From: Tim Townsend 
Sent: 09 May 2019 18:23
To: Daniel Vick
Subject: AL/32/19/OUT - WSCC Highways reponse dated 9th May 2019

WEST SUSSEX COUNTY COUNCIL
PLANNING SERVICES CONSULTATION

SUBJECT: AL/32/19/OUT - Outline application with some matters reserved for the erection of 55 No. dwellings, sustainable drainage measures, public open space, children's play area, landscaping & all other associated works (re-submission following AL/115/17/OUT). This application is a Departure from the Development Plan.

LOCATION: Wings Nursery, Lidsey Road, Aldingbourne, PO20 3SU.

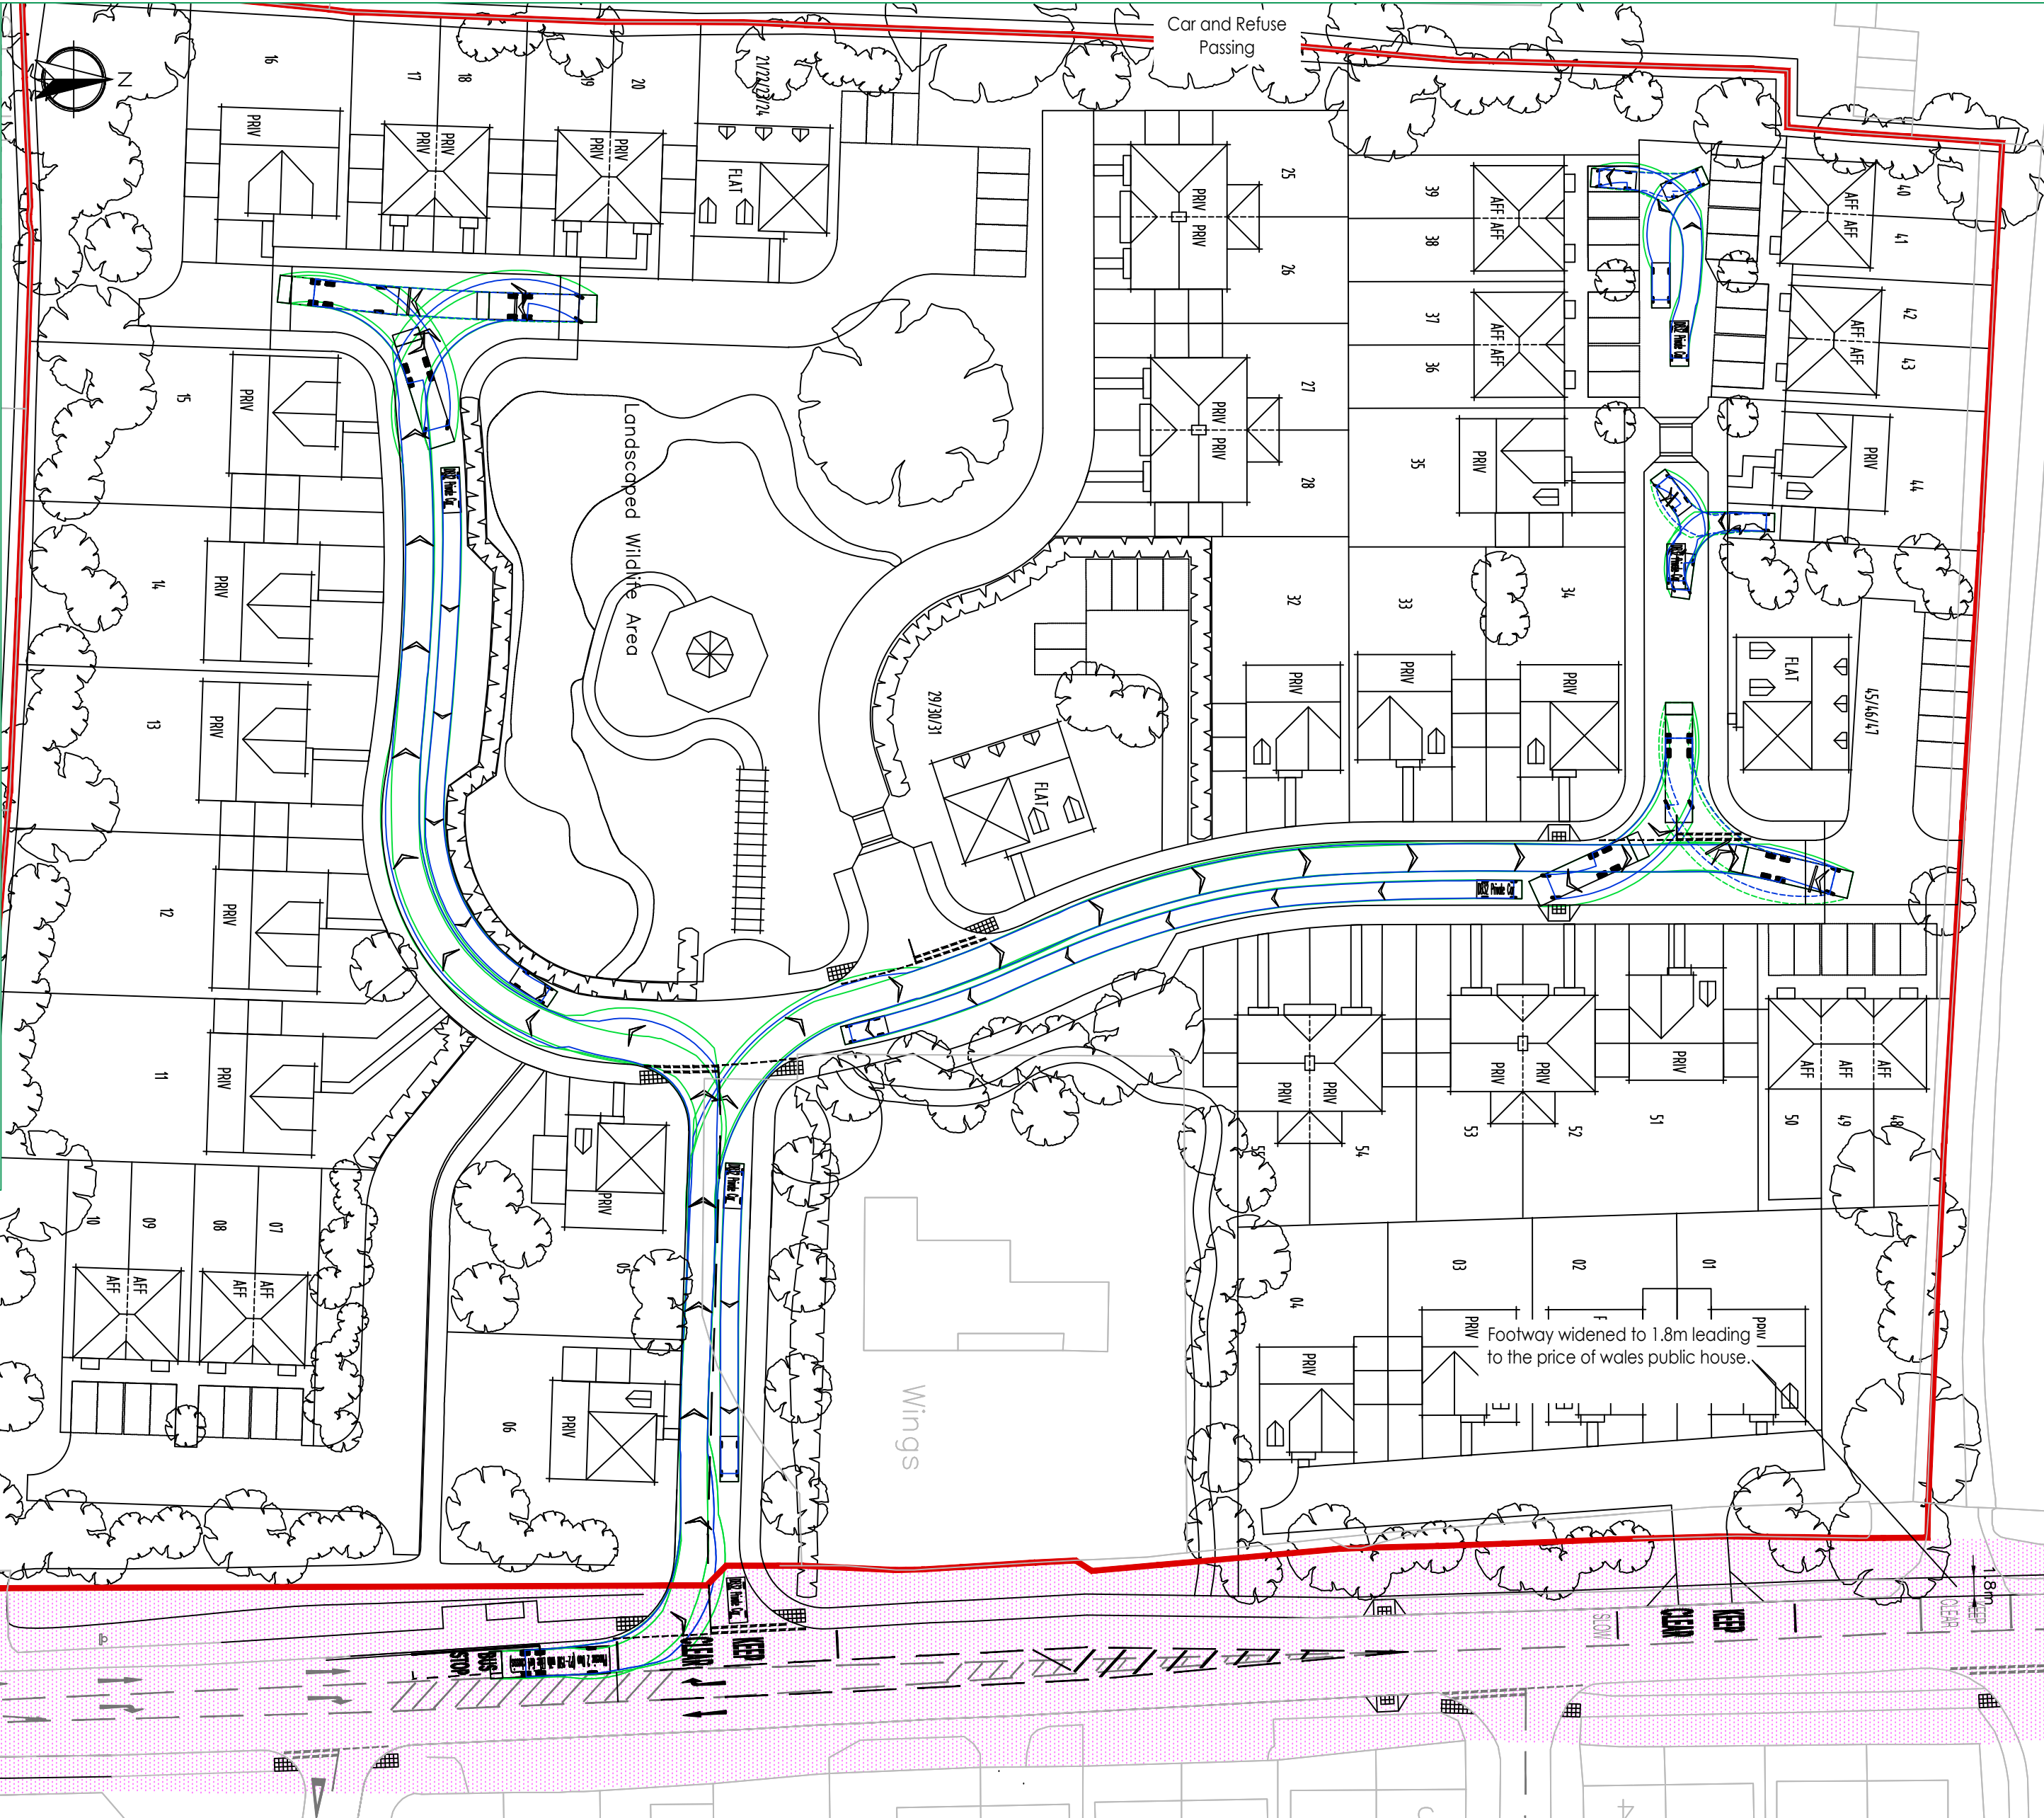
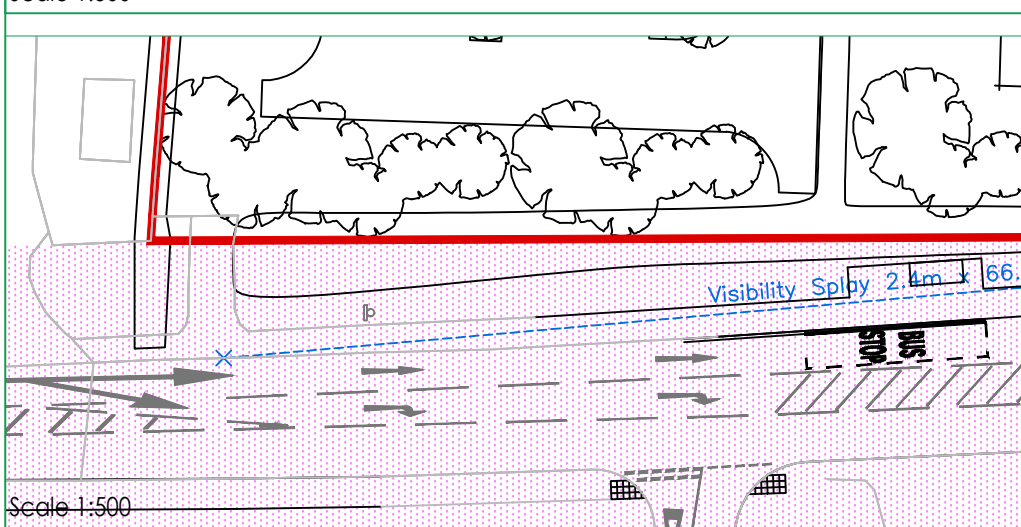
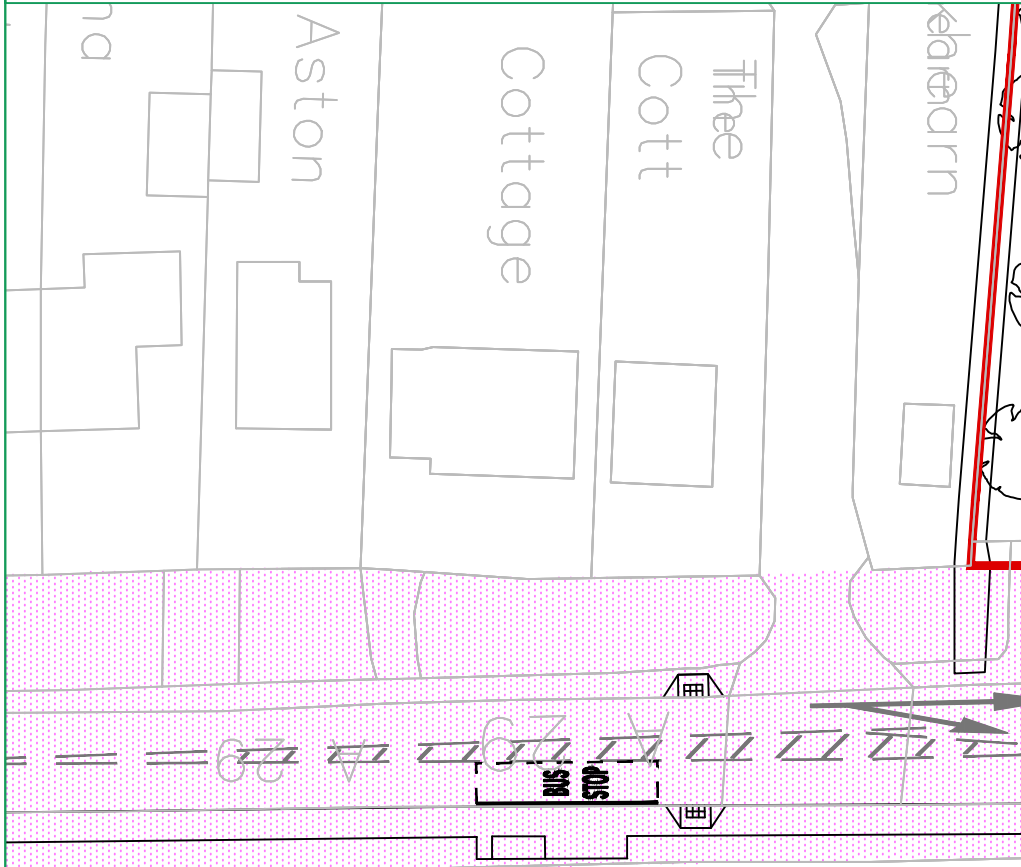
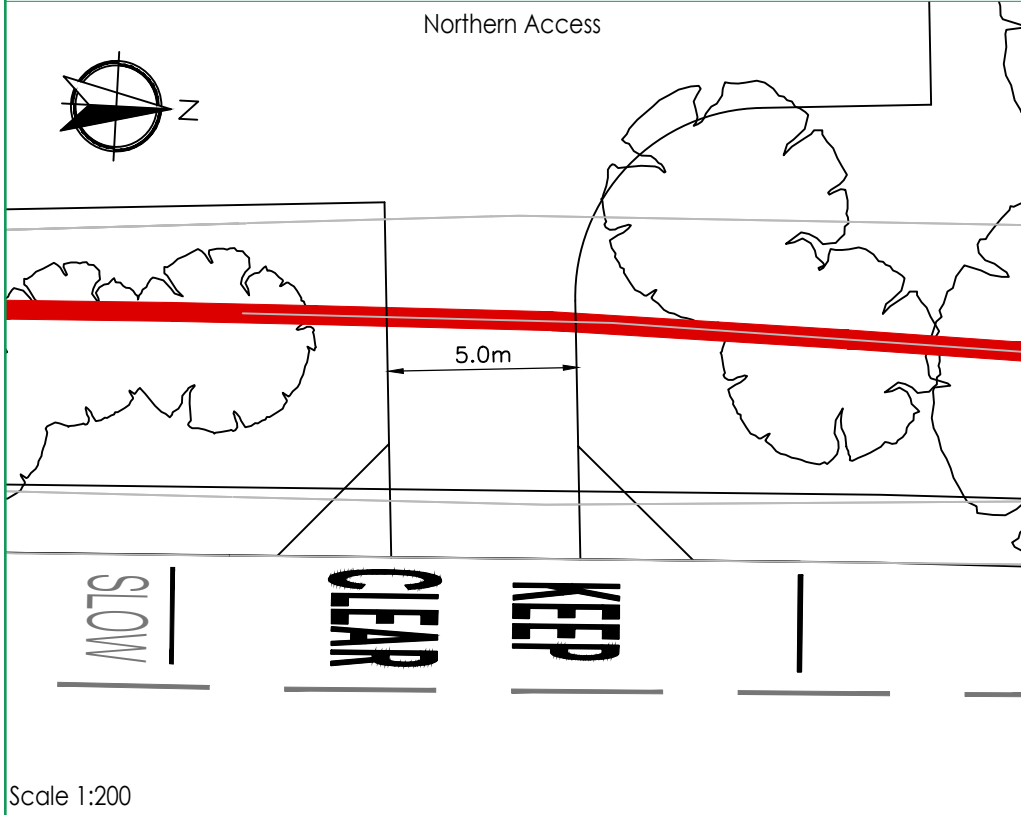
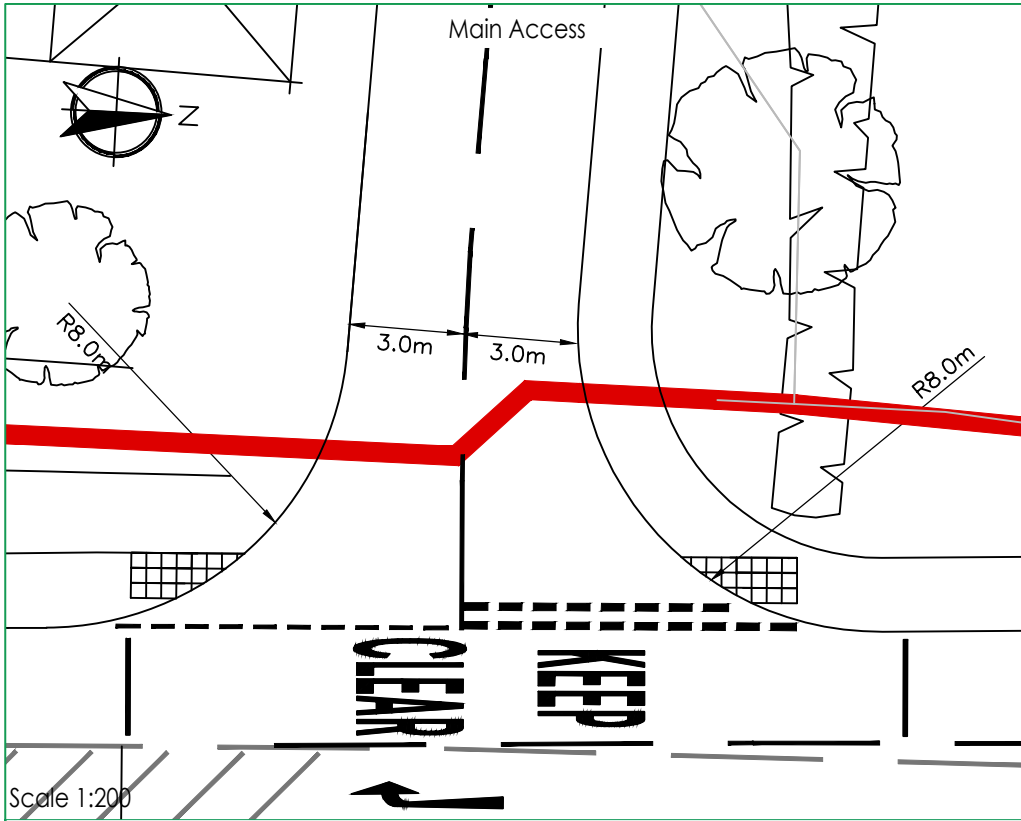
- 6.0m wide access road
- A 2m wide footway along the northern side of the access road linking to existing footways on Lidsey Road
- 6m bellmouth radii
- Alteration to the current white lined hatching on Lidsey Road (by removing some of the hatching replacing it with a waiting area to serve the site)

The Highway Authority has reviewed the information provided (including swept-path diagrams of vehicles entering and leaving the junction) and the arrangements are found to be satisfactory.

RGP Swept Path Analysis

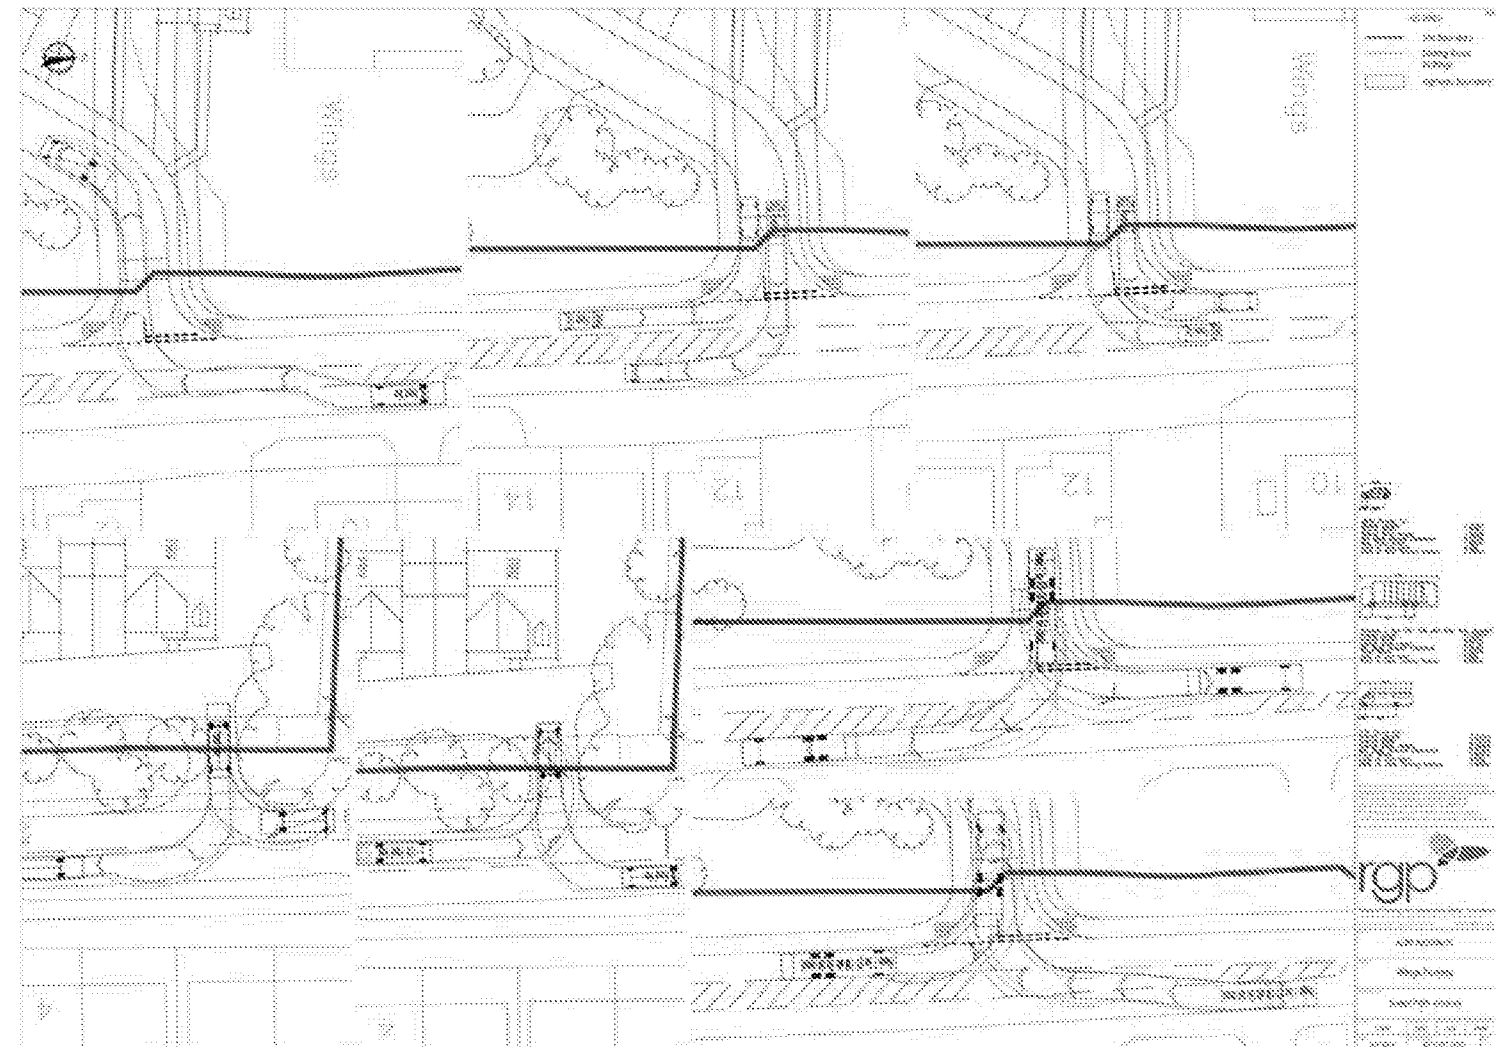
The Highway Authority previously had a concern about movement of larger vehicles through the junction in-so-far that such vehicles may find it difficult to turn into the junction or their path might be blocked while traffic is queuing in the primary site access. However, this has been addressed through slight widening of the junction and associated improvements to the turning lane on the A29 Shripney Road itself.
